Application by Drax Power Limited for the Drax Bioenergy with Carbon Capture and Storage Project

The Examining Authority's written questions and requests for information (ExQ2)

Issued on 19 April 2023

PROJECT:	DRAX BECCS DCO				
TITLE:	FIGURE 1 LANDSCAPE AND BIODIVERSITY MITIGATION PLAN

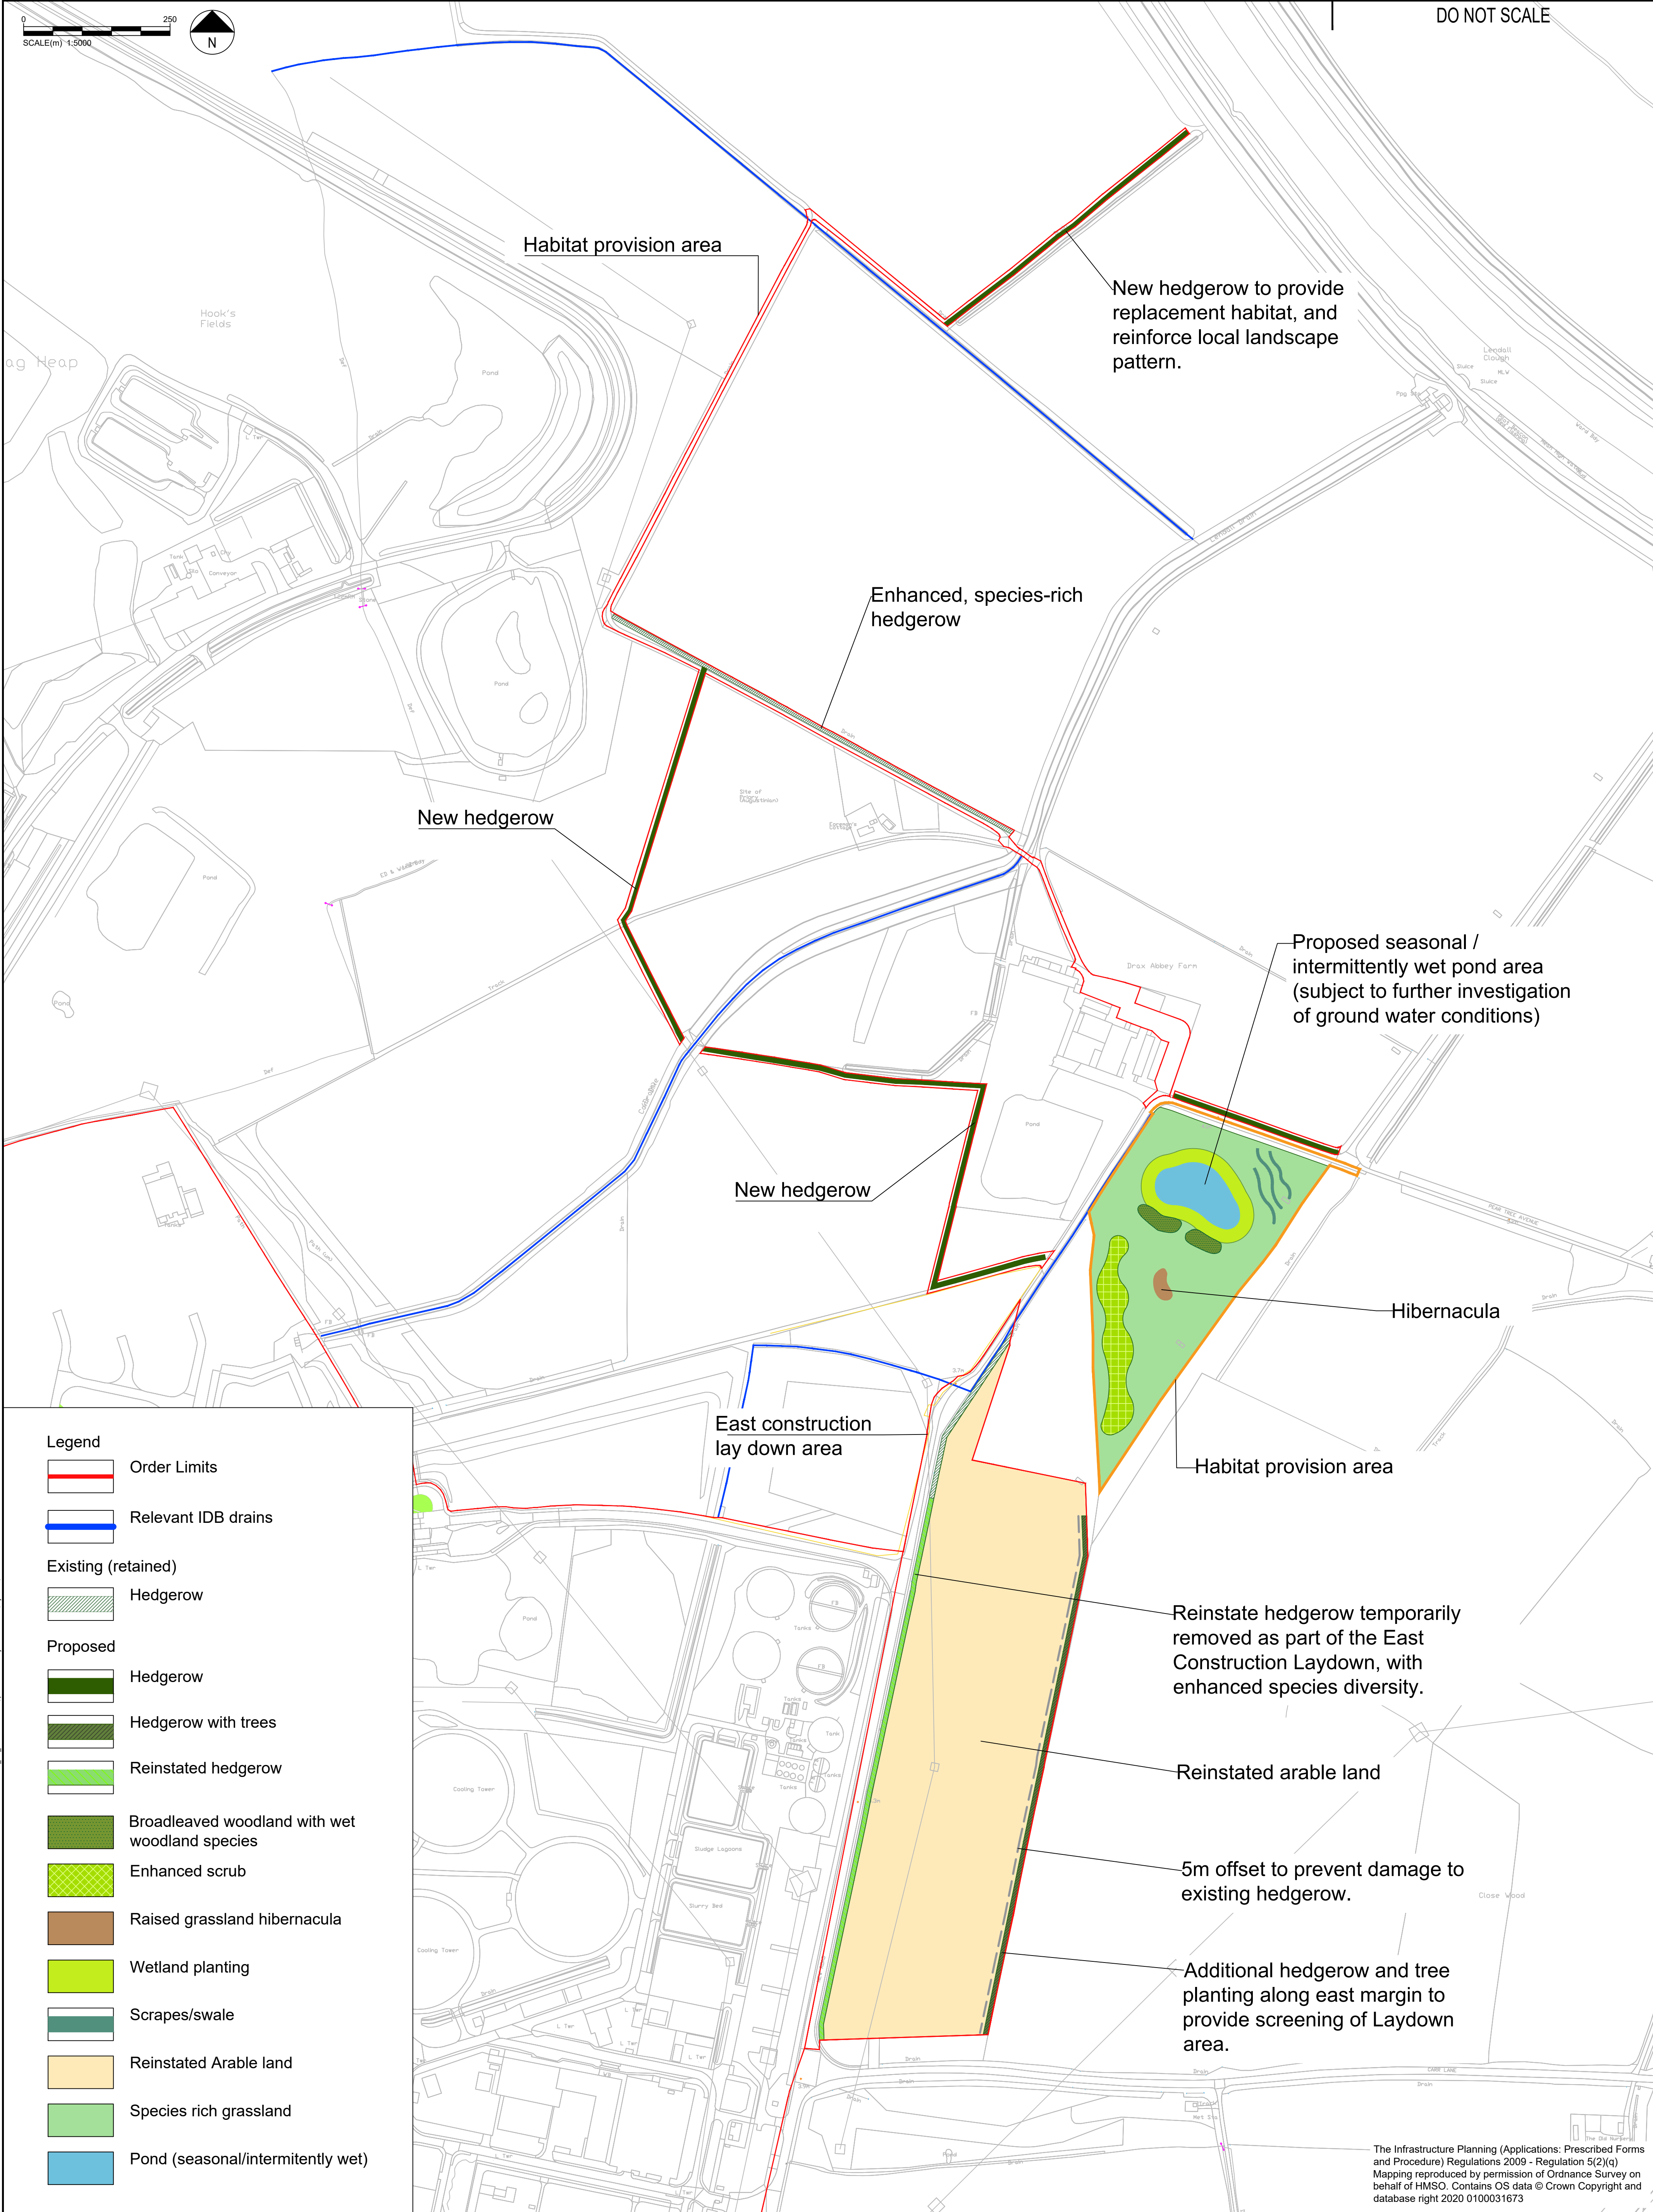
DLV.2.3	Applicant	<p>Paragraph 5.1.2 of the updated OLBS [REP5-013] includes two new planting types (Amenity planting within the main Drax Power Station; and New Broadleaved Planting within the main Drax Power Station) and refers to the Landscape and Biodiversity Mitigation Plan (Figure 1) [APP-181]. Will the Applicant be submitting an updated version of Figure 1 into the Examination that includes the additional planting types?</p>
DLV.2.4	NYC	<p>NYC is asked to provide comments on the Applicant's updated OLBS [REP5-013] and the Applicant's Responses to Issues Raised at D4 [REP5-028] in relation to the concerns raised in its D4 submission [REP4-042], including whether its concerns on the following matters have been addressed and if not, what information NYC requires to address these concerns:</p> <ol style="list-style-type: none"> Long-term Maintenance and Management of Landscape. Removal of existing vegetation. Protection of existing trees. The landscape mitigation plan for works other than the habitat provision area.
